ASSESSMENT REPORT

EASTERN CREEK BUSINESS HUB, ROOTY HILL SSD 5175 MOD 2

Figure 2 – Location of the proposed loading dock

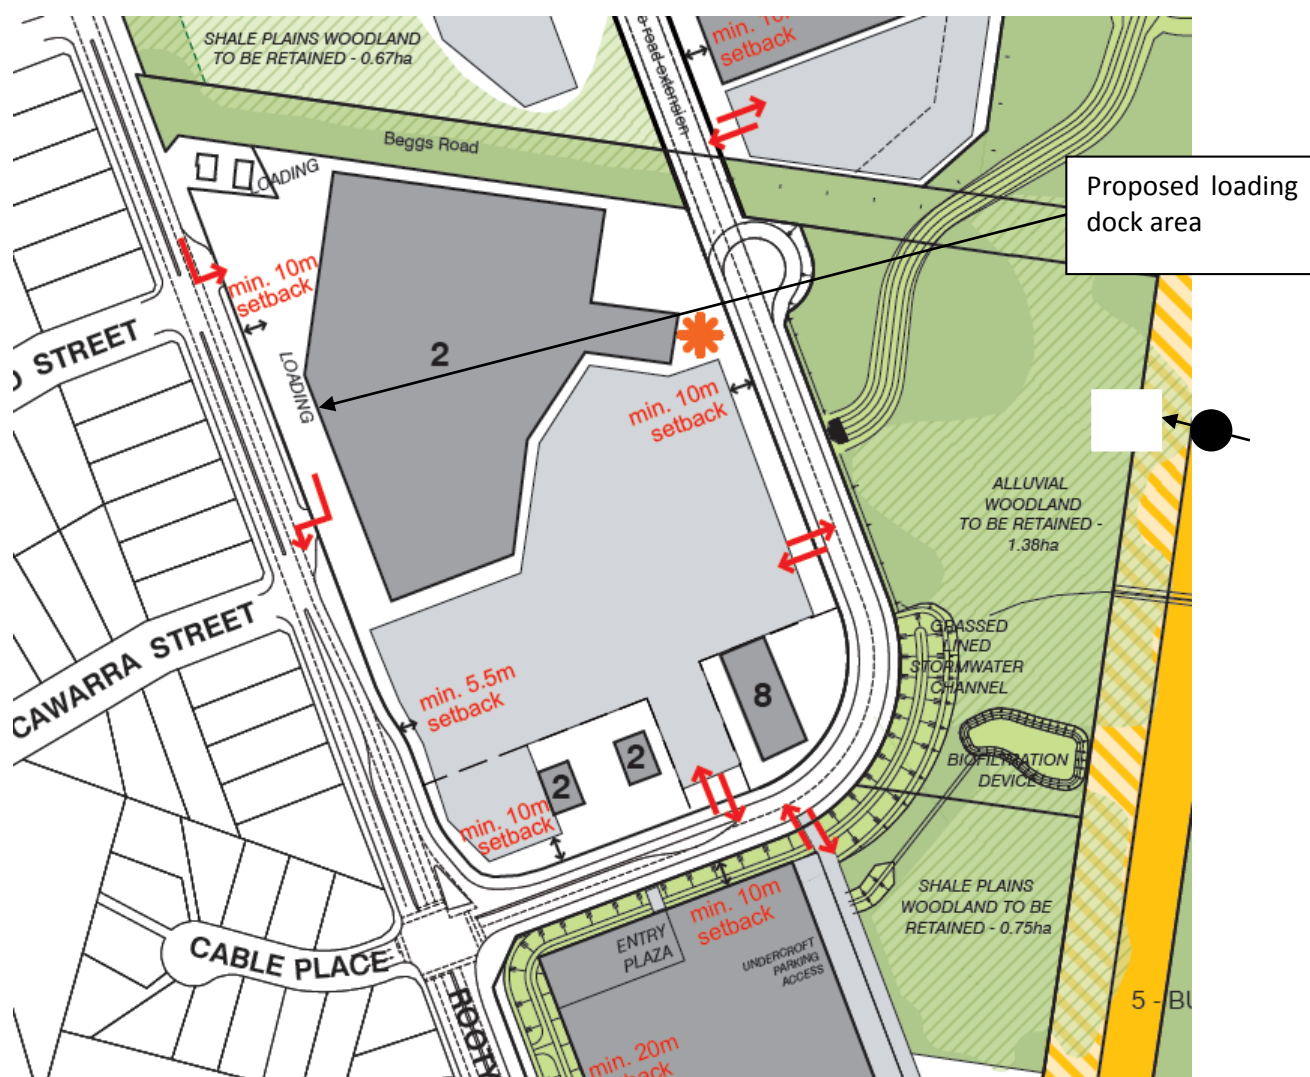
- the loading dock should be relocated adjacent to the northern boundary or recessed into the building to reduce visual, acoustic and odour impacts on the adjacent dwellings

Council raised concern about the potential visual impacts of the new building envelope, particularly the proposal to incorporate the loading dock and service area on the Rooty Hill Road South façade. As such, Council suggested further information be provided about the treatment of the façade and the incorporation of further controls in the Urban Design Guidelines, including:

The Department has considered the potential visual impacts of the modification and considers that subject to appropriate detailed design at the future DA stage, the appearance of the building and loading dock when viewed from Rooty Hill Road South, would be acceptable as:

- the amalgamation of the building forms results in a reduction in the extent of building massing fronting Rooty Hill Road South as the overall street facing façade length is reduced and building envelope height remains unchanged
- the overall built form would still be consistent with the emerging character of the site which will primarily accommodate retail development in large format arrangements
- the natural slope of the site, and an acoustic wall would partly screen the development and reduce its visibility from the street (see **Figure 5**)
- the visual impacts of the future building and street activation can be appropriately managed as part of the detailed design at DA stage through the use of appropriate façade treatments, materials and architectural screening, and the updated Urban Design Guidelines are considered to provide appropriate guidance in this regard.

The Department considers the proposed changes would not result in unacceptable visual impacts and that appropriate controls have been incorporated into the Urban Design Guidelines to ensure future development presents a high quality visual appearance.

These units would predominantly operate during the day, with the potential to operate with extended hours. Acoustic treatment to these units may be required to ameliorate noise impact to the surrounding residents and to comply with the criteria specified in this report and verified at CC stage.

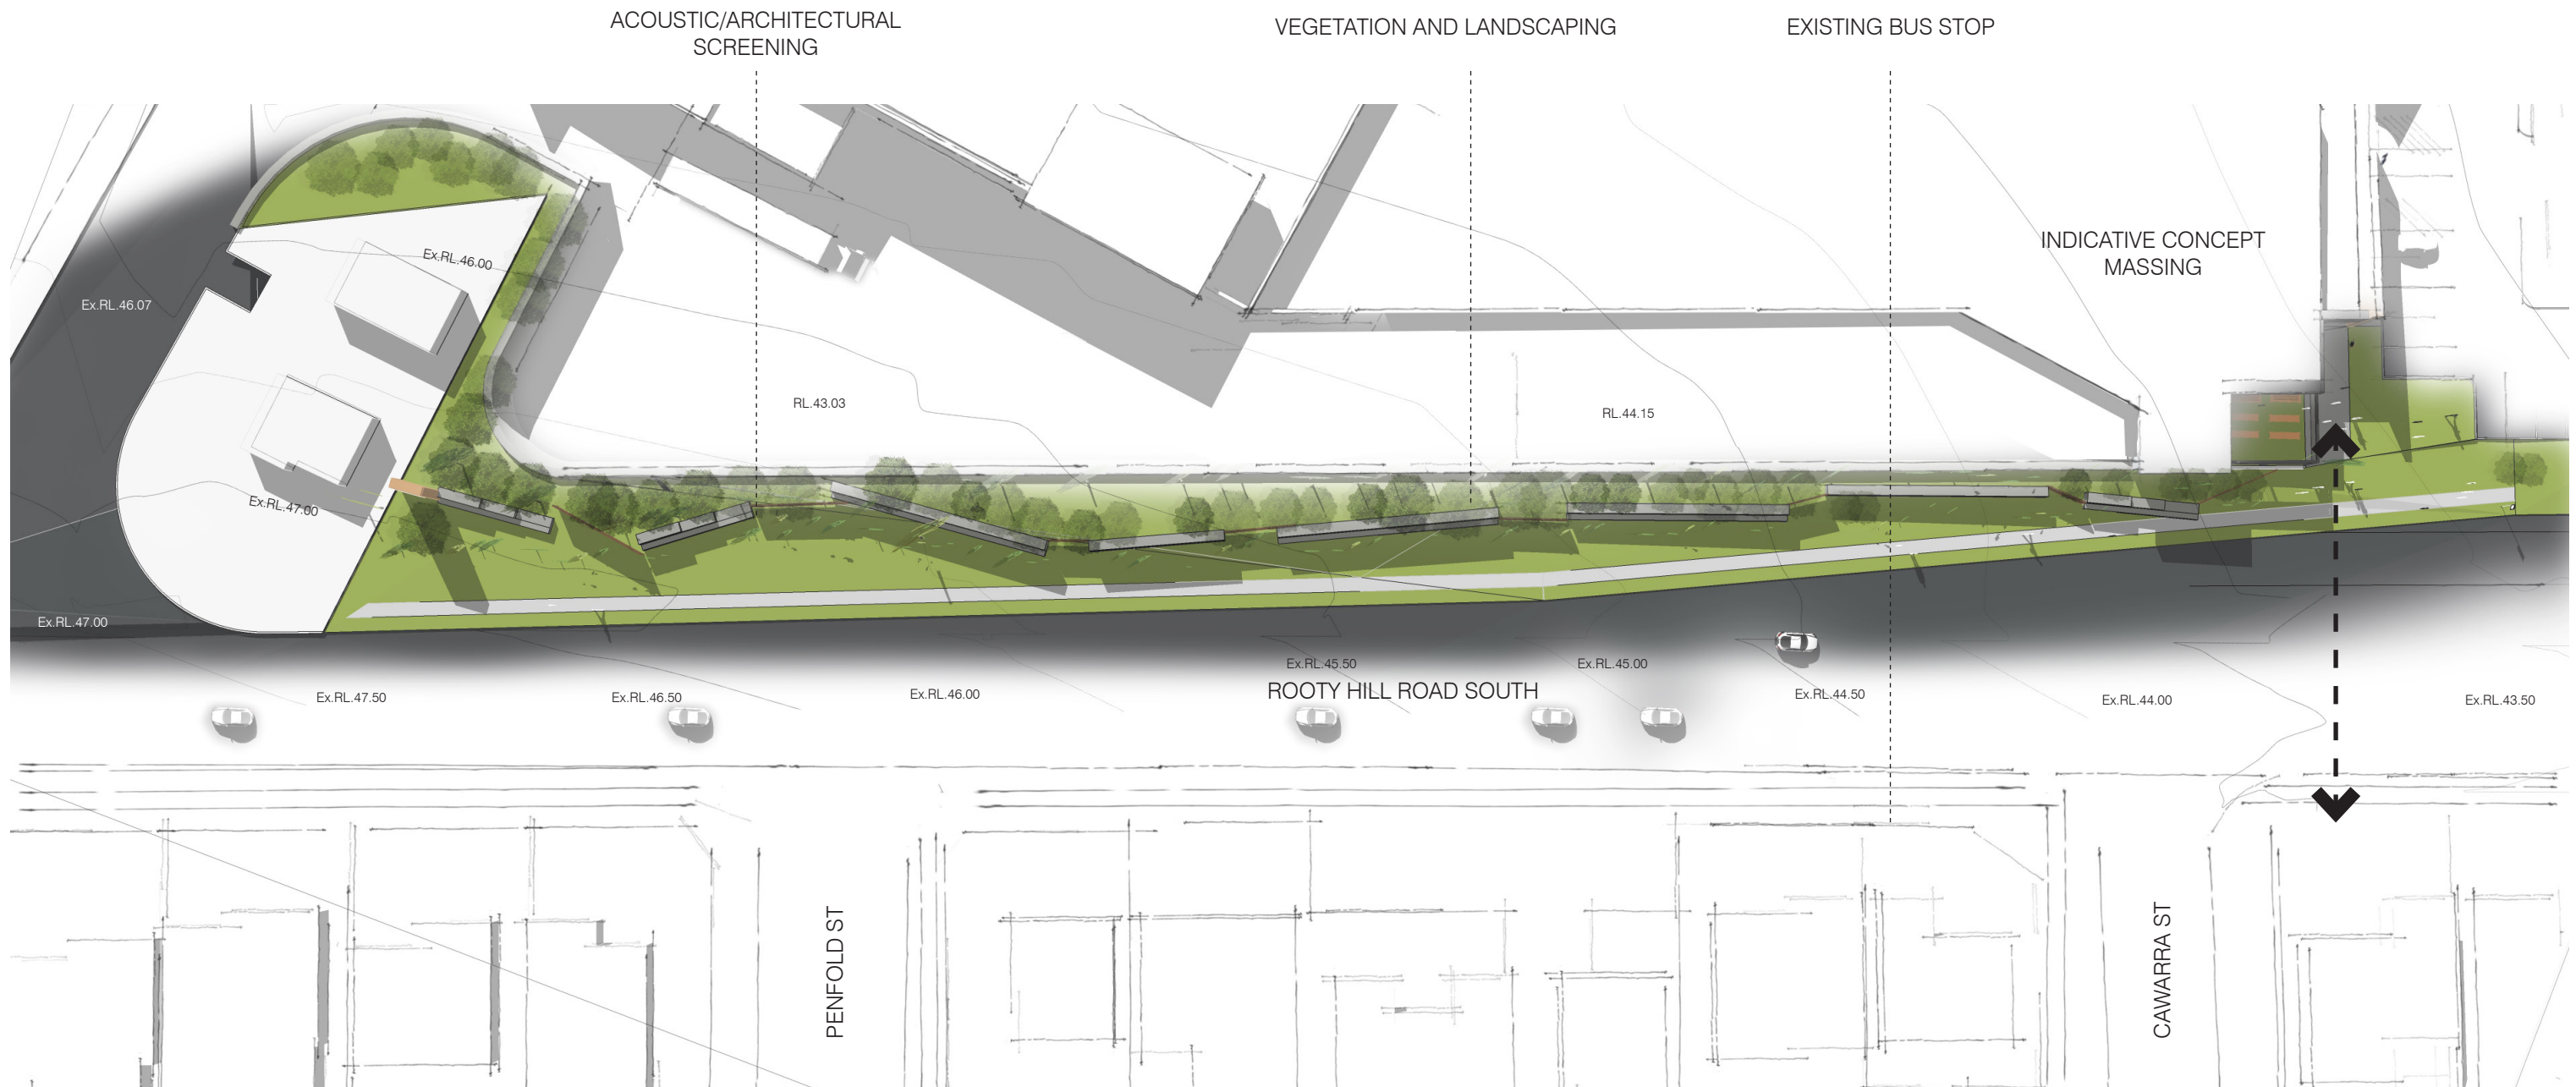
- 40% building façade to be activated
 - a maximum of 3 freestanding signs across the site
 - appropriate screening and landscaping to Rooty Hill Road South

- building frontages to address the streets
- 40% of the building façade to be activated
- appropriate screening and landscaping to Rooty Hill Road South.

In response, the Applicant updated the Urban Design Guidelines to incorporate Council's suggestions.
